**COMBINED PRELIMINARY AND FINAL DRAINAGE
REPORT**

**OHANA SUBDIVISION
EL PASO COUNTY, COLORADO**

October 28, 2021

FINAL PLAT OHANA ACRES

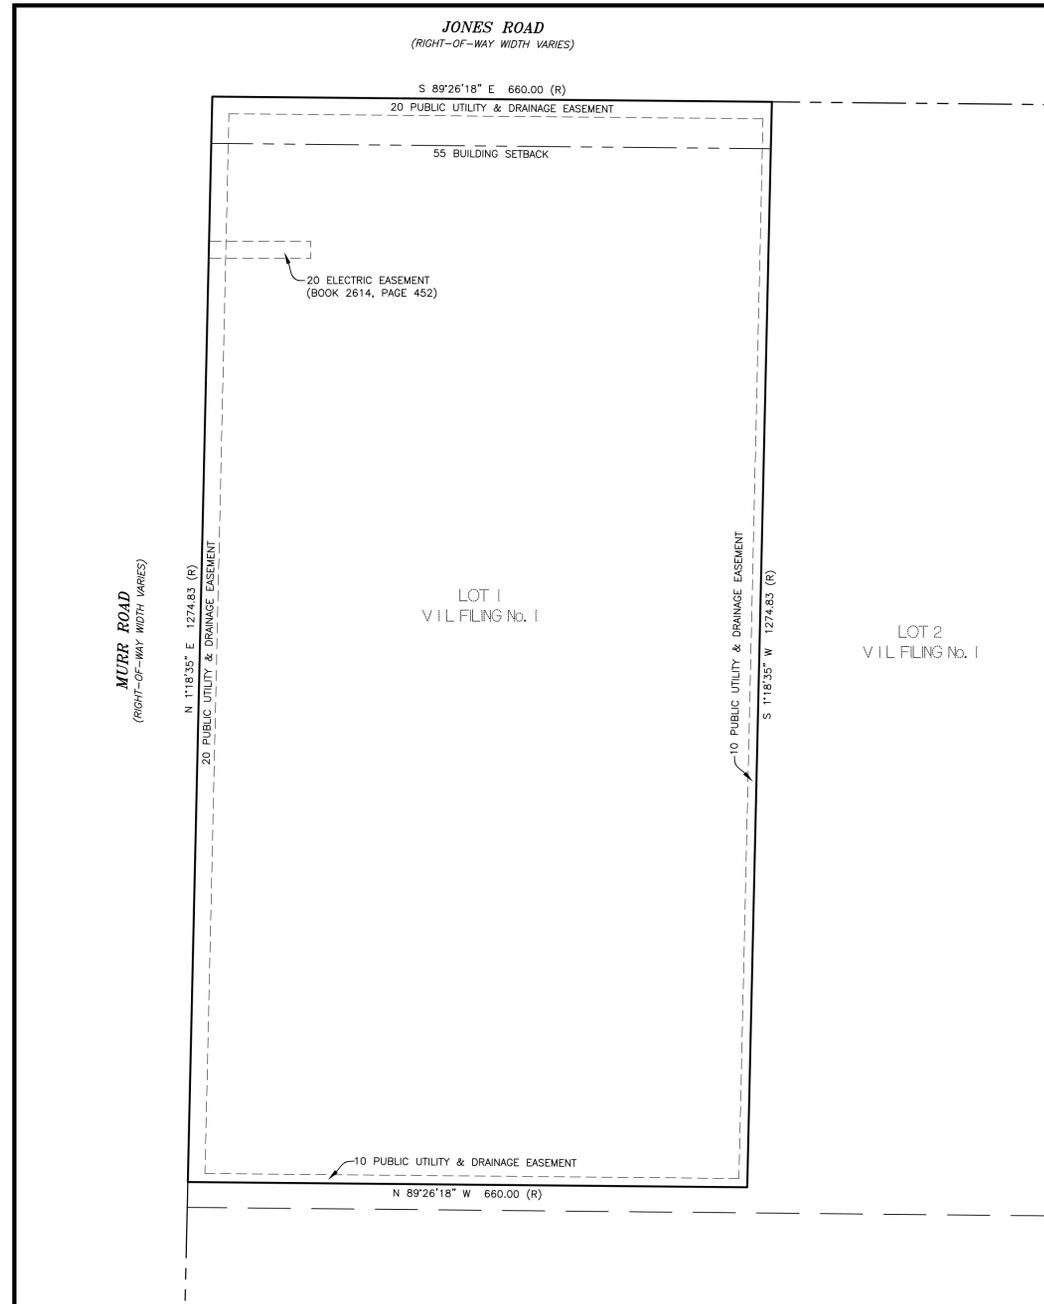
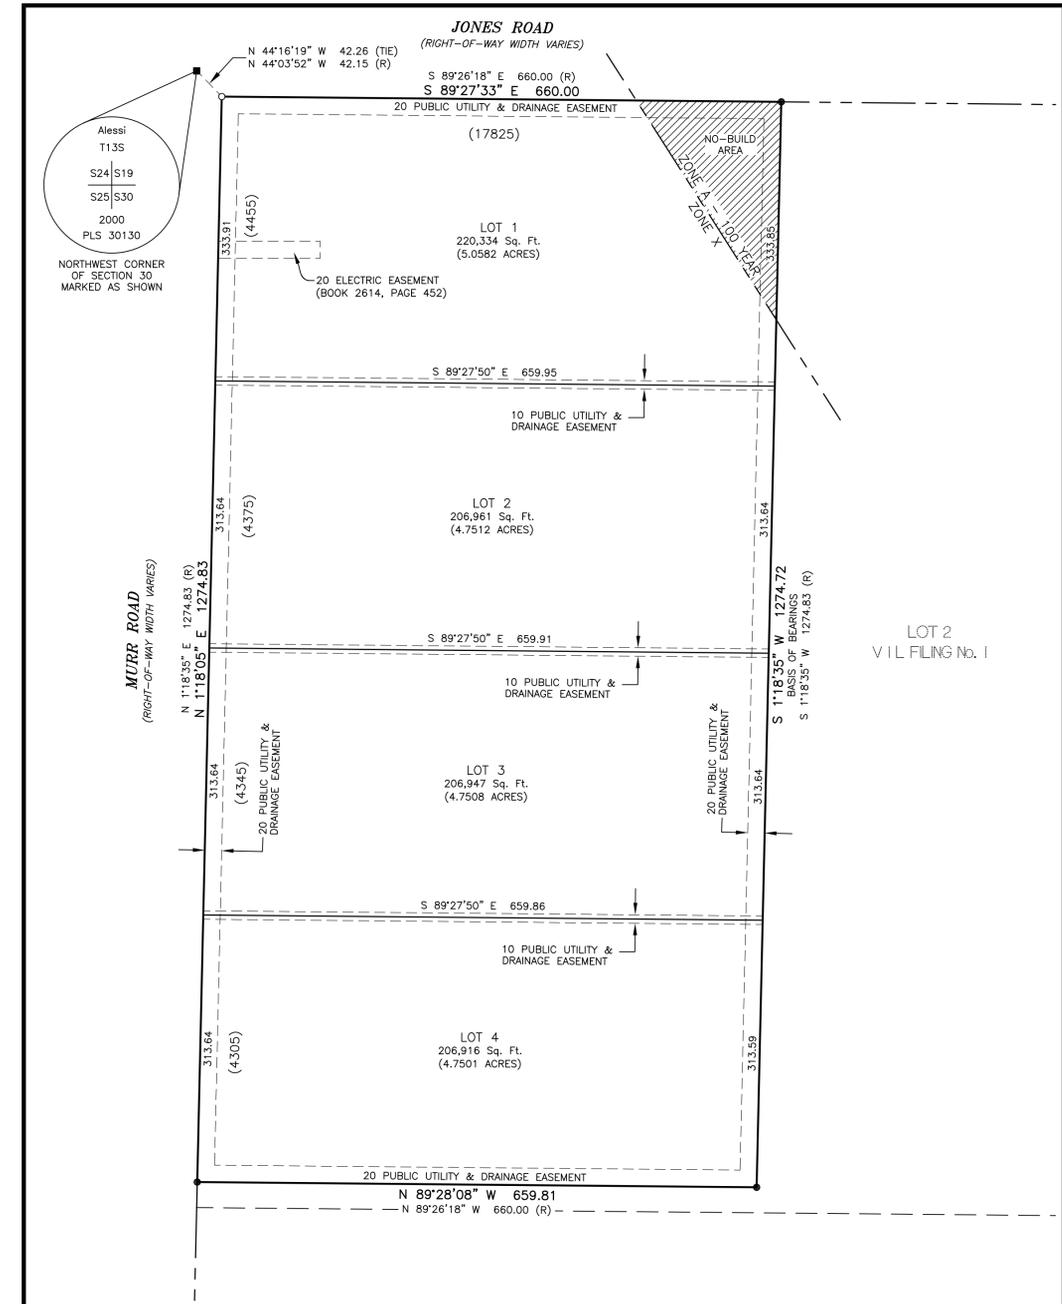
State that this area will be a "No-build area" on the plat.
